KITTITAS COUNTY DEPARTMENT OF PUBLIC WORKS

RE: Love's Truck Stop, SE-19-00014

Public works has reviewed submitted materials for Love's Truck Stop in Easton, WA. Our SEPA comments appear below for your consideration.

**PRELIMINARY STORMWATER PROFILES**

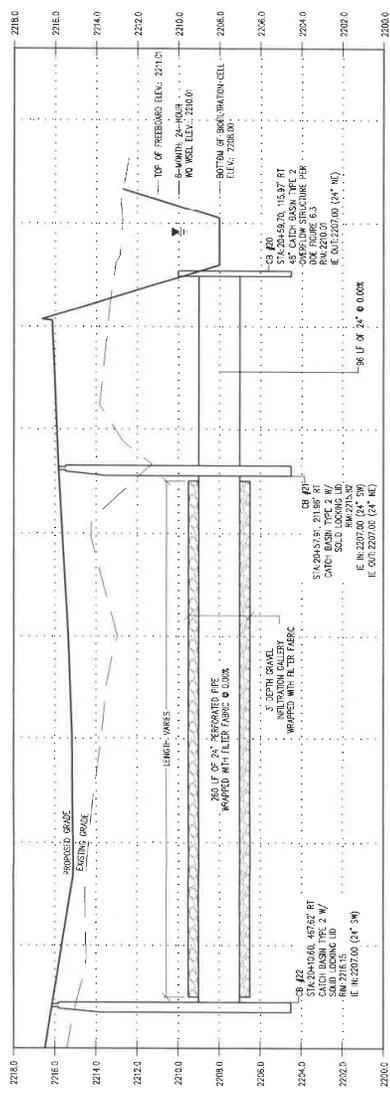
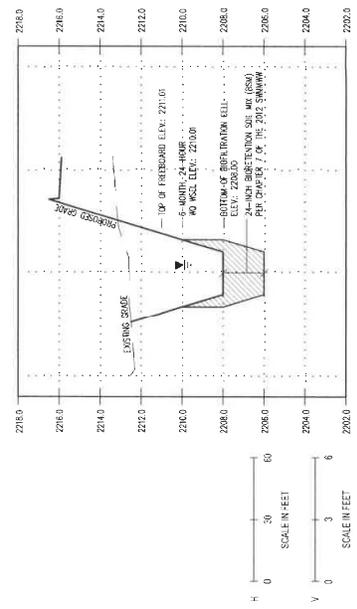
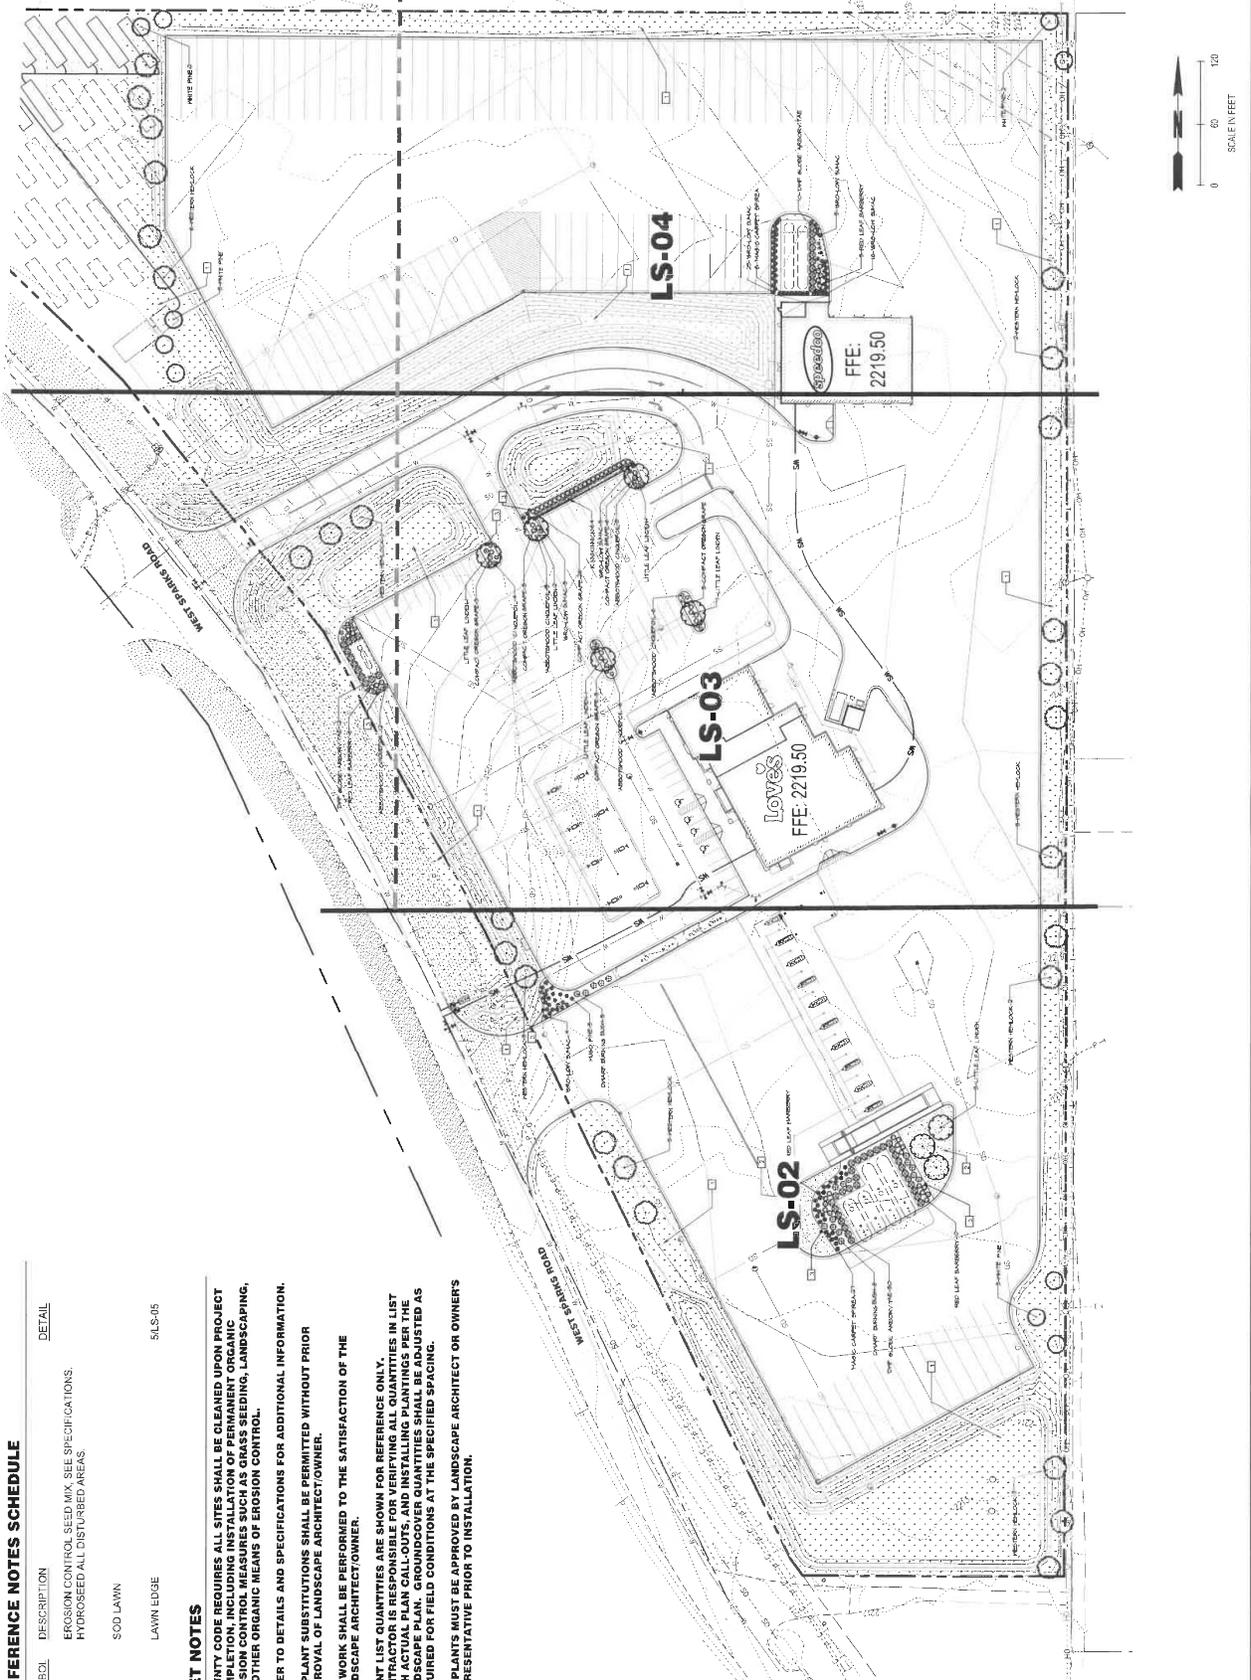
4. Public Works will review the stormwater plan for the site once a plan (sealed by a professional civil engineer in the State of WA) is received for review.
